Historic England

18 May 2020

**HEYFORD PARK CAMP ROAD UPPER HEYFORD BICESTER OX25 5HD
Application No. 18/00825/HYBRID**

FIG 6 COMPOSITE PARAMETER PLAN

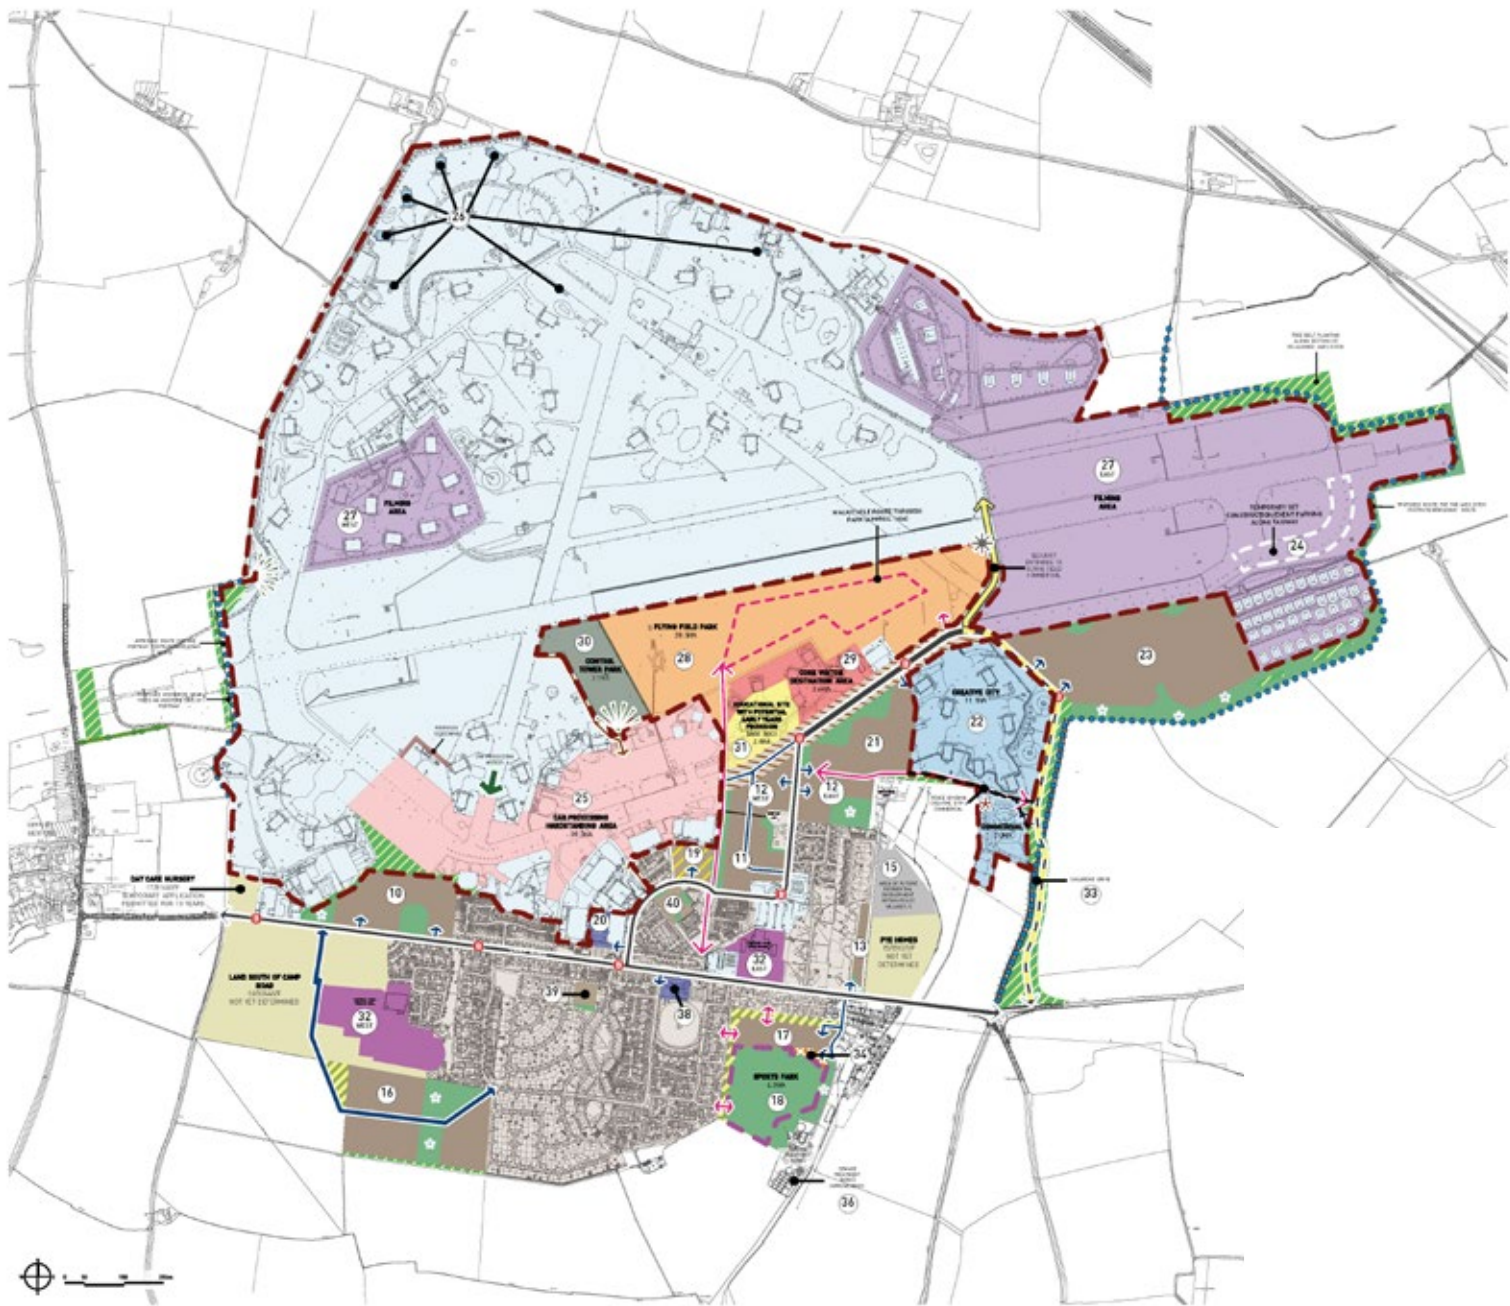
- The height parameters plan draws development associated with the creative city back from the southern taxi way in order to lessen the impact of this development on the flying field.

New employment uses are proposed principally in a group of HASs located towards the south east corner of the site. In our letter of 9 July 2018 we expressed concern that the new structures associated with commercial use subsumed the HASs. While the parameter plans have pulled the area of additional development away from the southern taxiway, which is a positive move, the parameters plan still shows these structures potentially entirely surrounded by new buildings up to 18 metres high (the HASs are only 8.3 metres high internally). Our concerns about this group being subsumed by new development therefore still stand.
